From: Fiona Fitzgerald
Sent: 11 March 2019 10:25
To: Planning.Responses
Cc: Michael Eastham
Subject: Saltbox - BE/135/18/PL

In response to the Sharps Redmore Acoustic report for Saltbox, Bognor Regis, Sussex, Project Number: 1818341, dated 6th December 2018 Environmental Health have responded with respect to each unit as this follows the set-up of the acoustic report:

A: With Acoustic Barrier Daytime L_{Aeq}

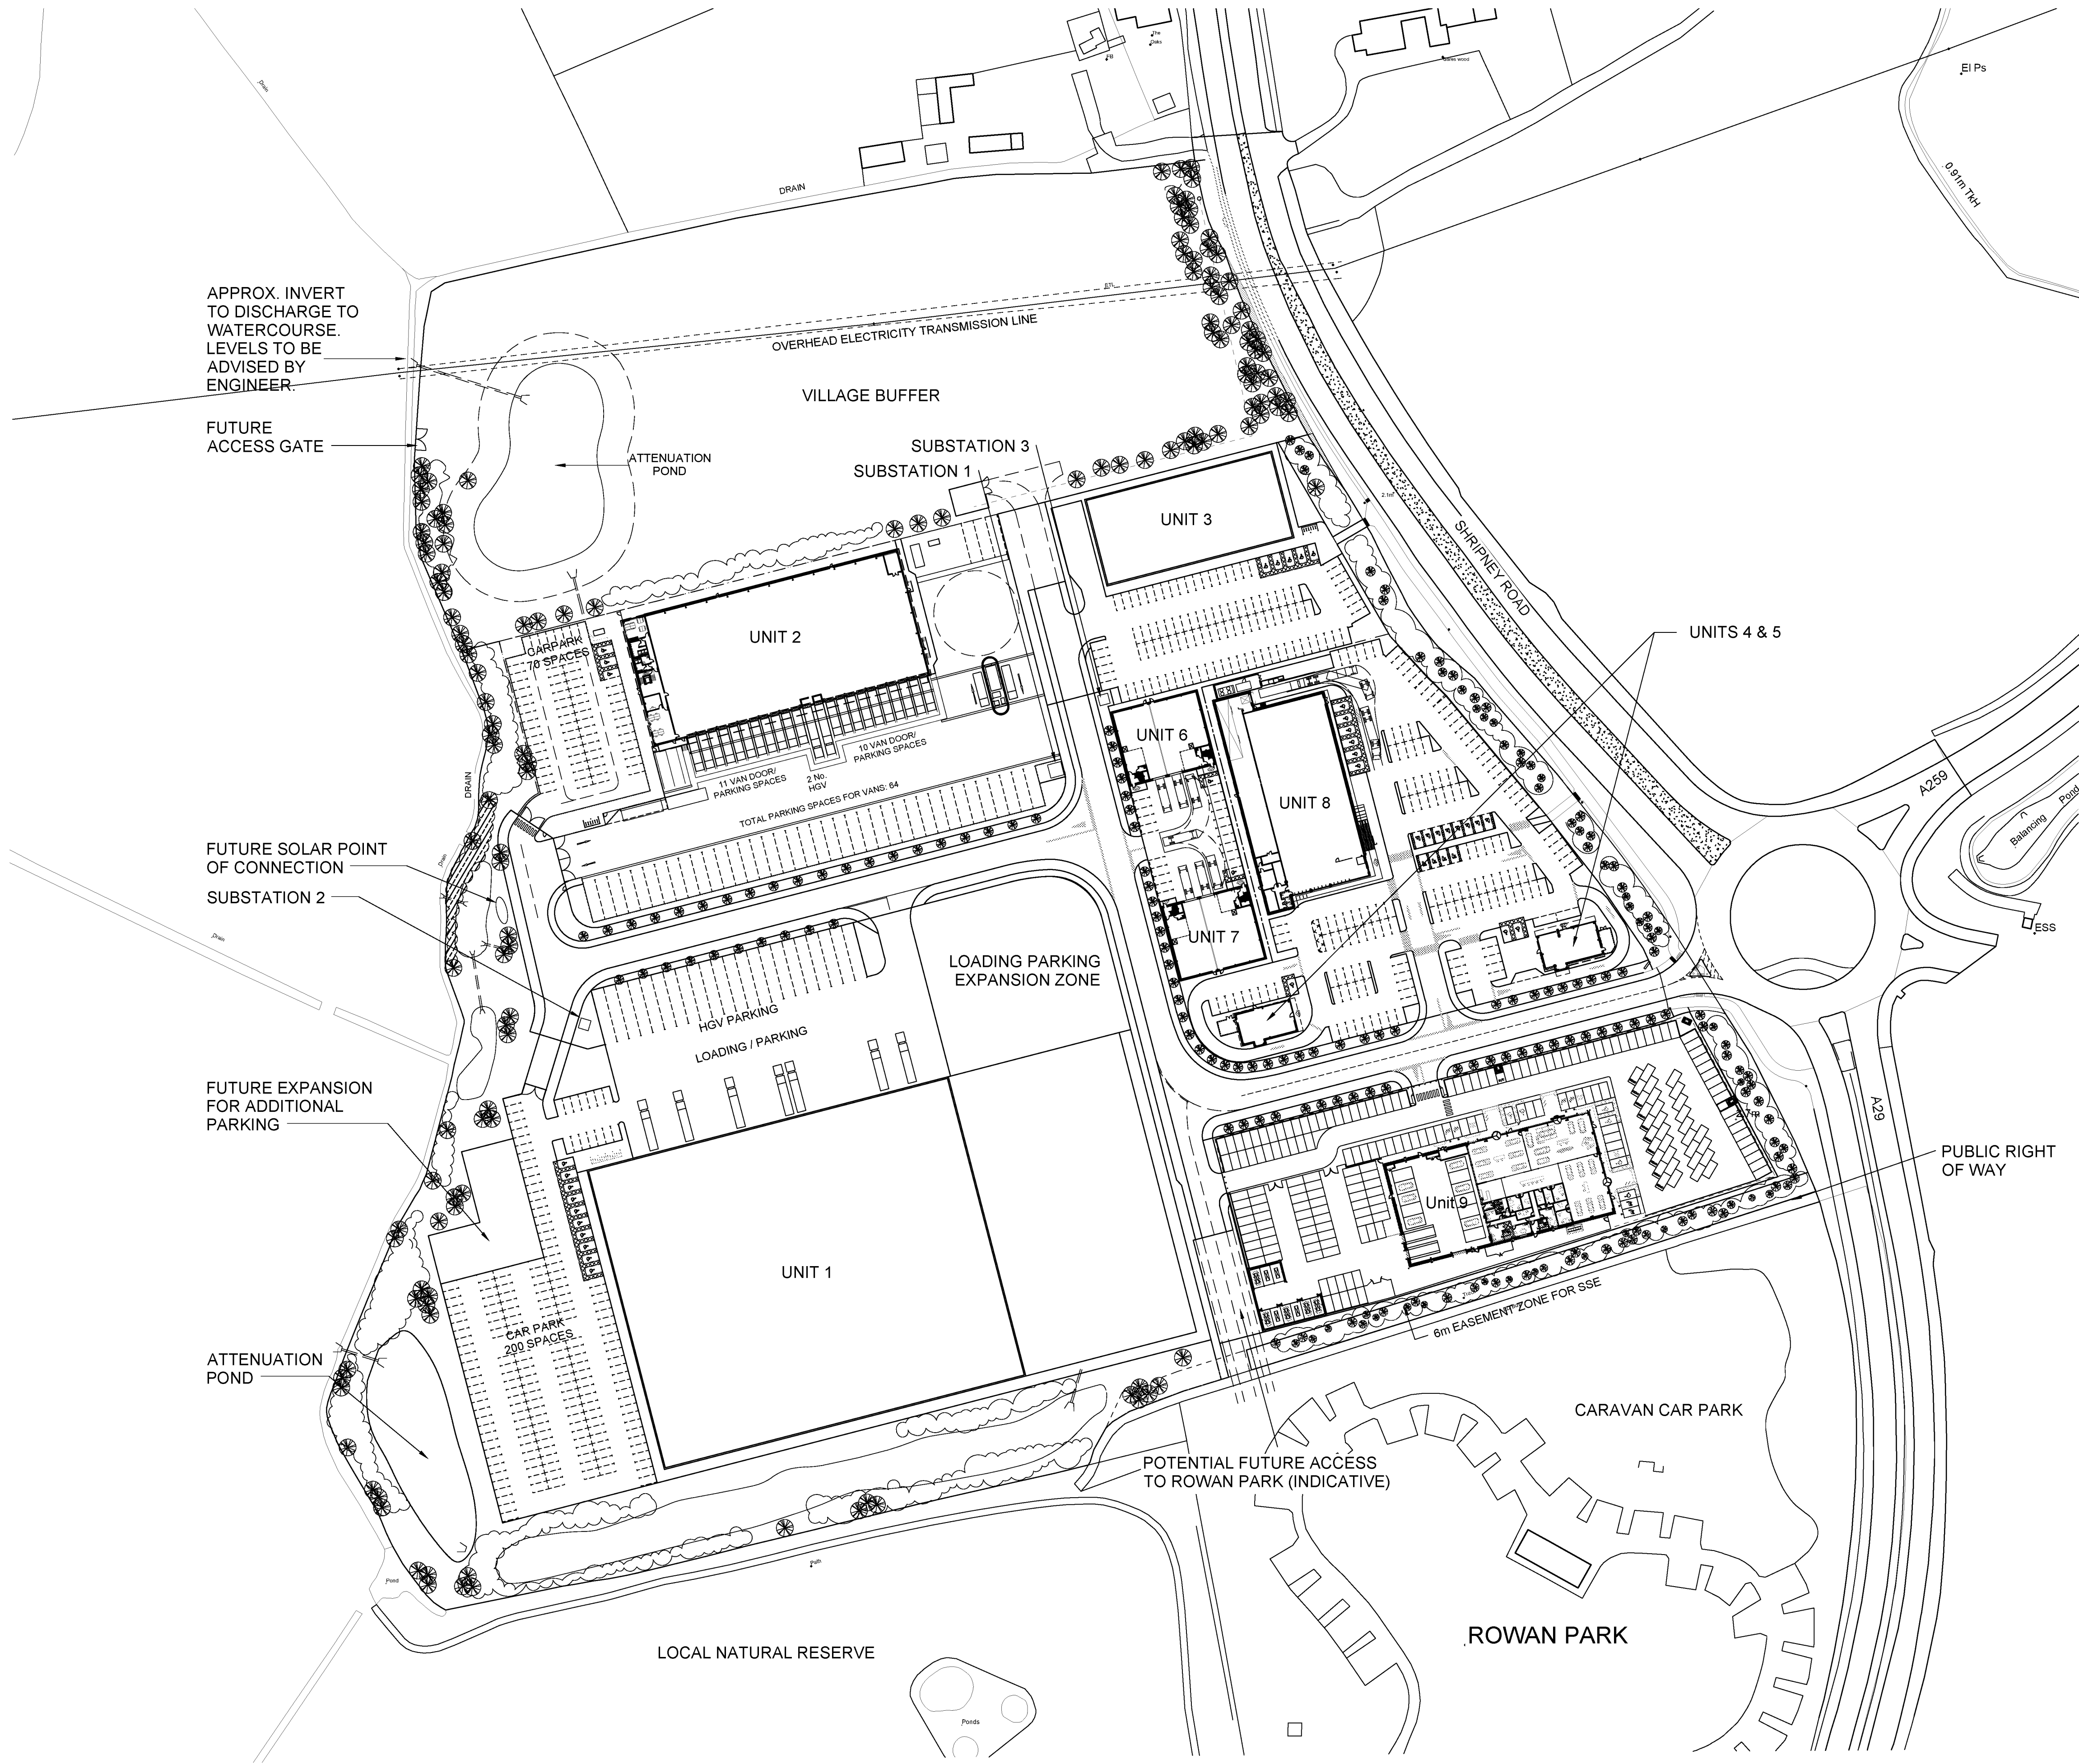
14. Please could the applicant provide a Soundplan map showing 'with acoustic barrier Night-time LAeq' as only the daytime one is provided.

15. In Appendix A the LAMax with Acoustic Barrier map does not detail whether this is daytime or nighttime. Please could this be clarified?

16. It would appear from Appendix A daytime that the LA_{max} levels will vary from 50-53dB (southern part of the caravan site) to 53-56dB (northern part of the caravan site). This therefore varies from moderate annoyance to above serious annoyance under the WHO guidelines. Part of the caravan site also falls into the 60-62dB LA_{max} contour, so again, above the WHO guidelines.
